# VOLLMER ROAD (NORTH)

### GRADING AND EROSION CONTROL PLANS

#### FEBRUARY 2022

EPC STORMWATER REVIEW COMMENTS ARE SHOWN IN ORANGE BOXES WITH BLACK TEXT

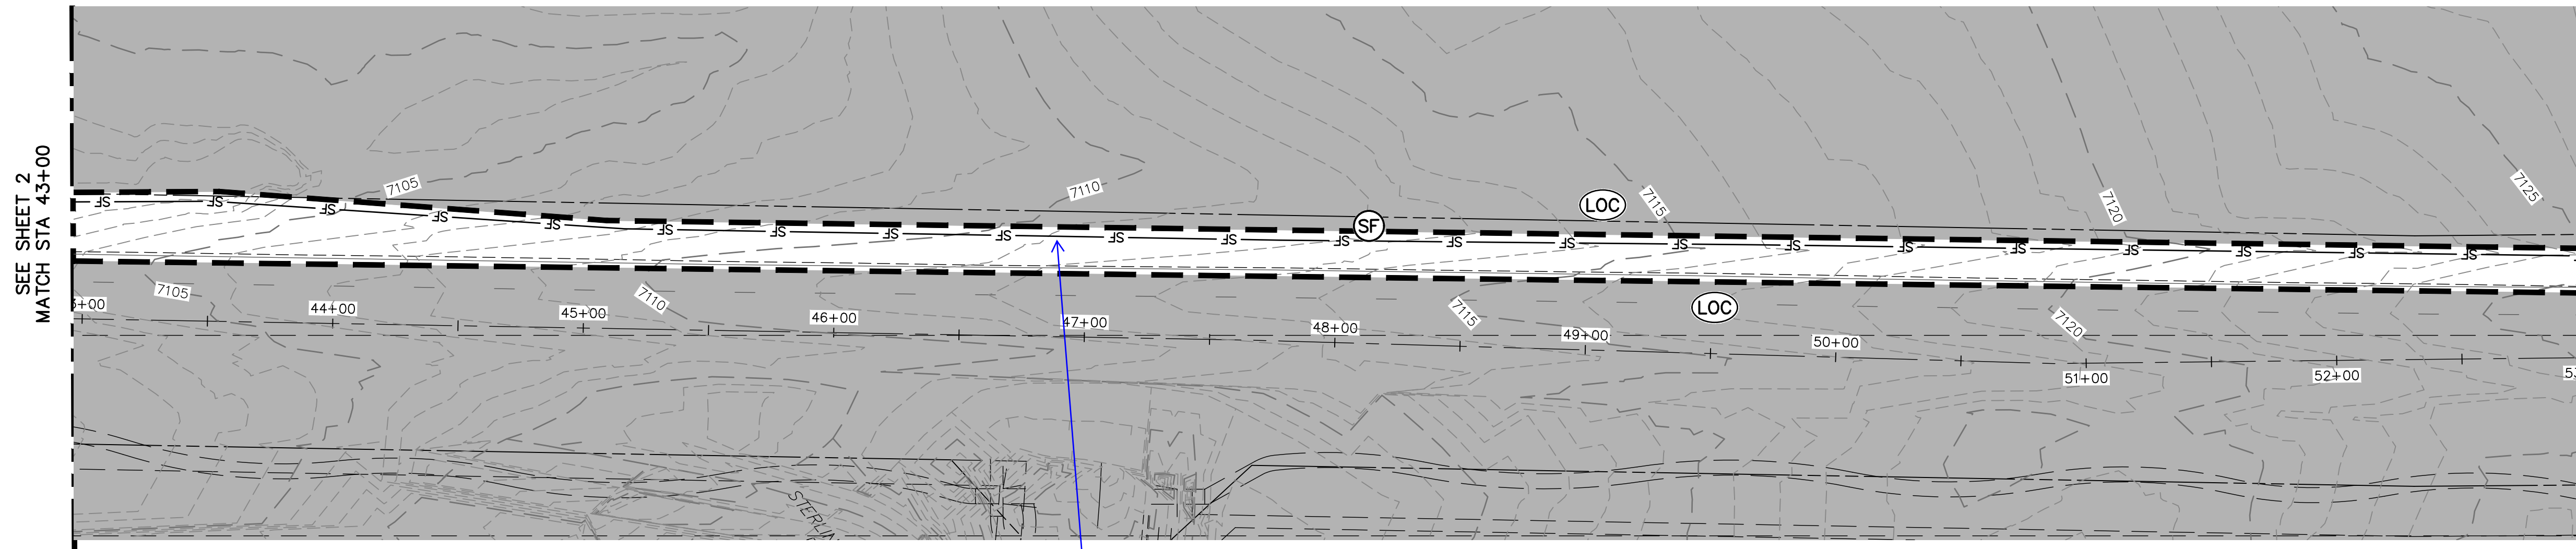
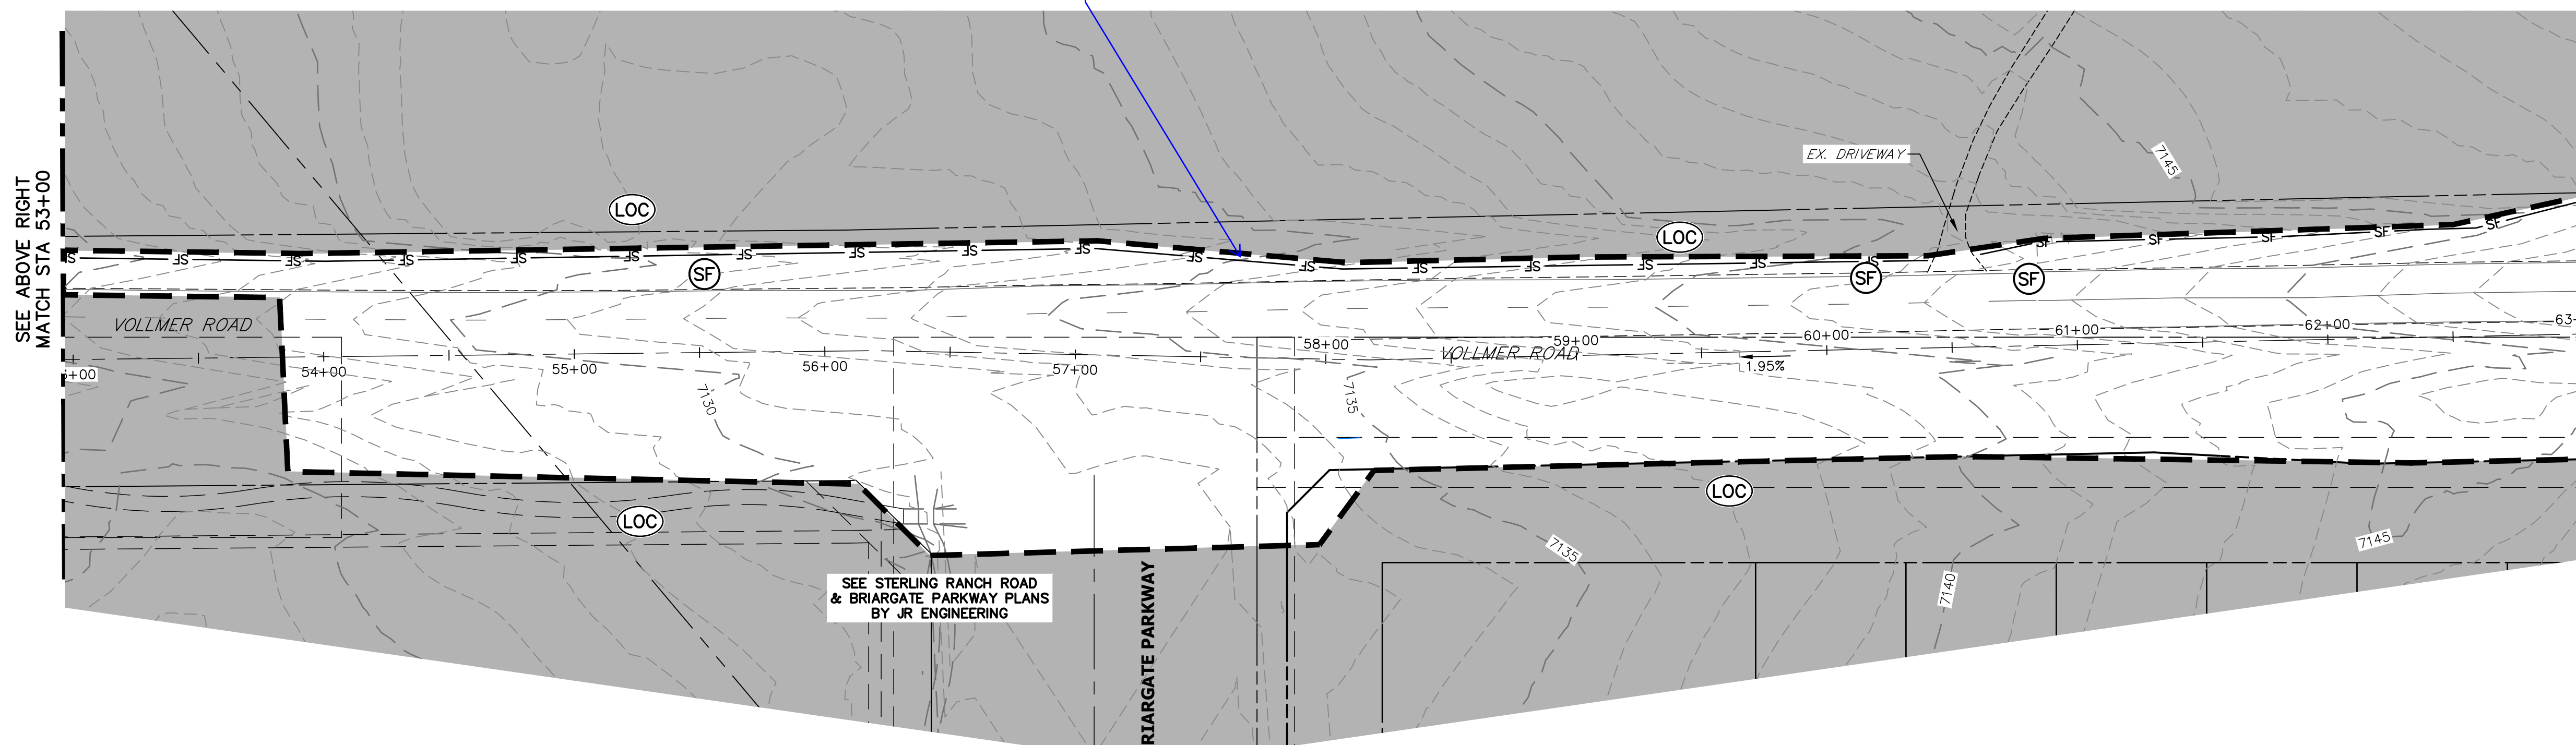
please add a note stating no batch plants will be utilized onsite
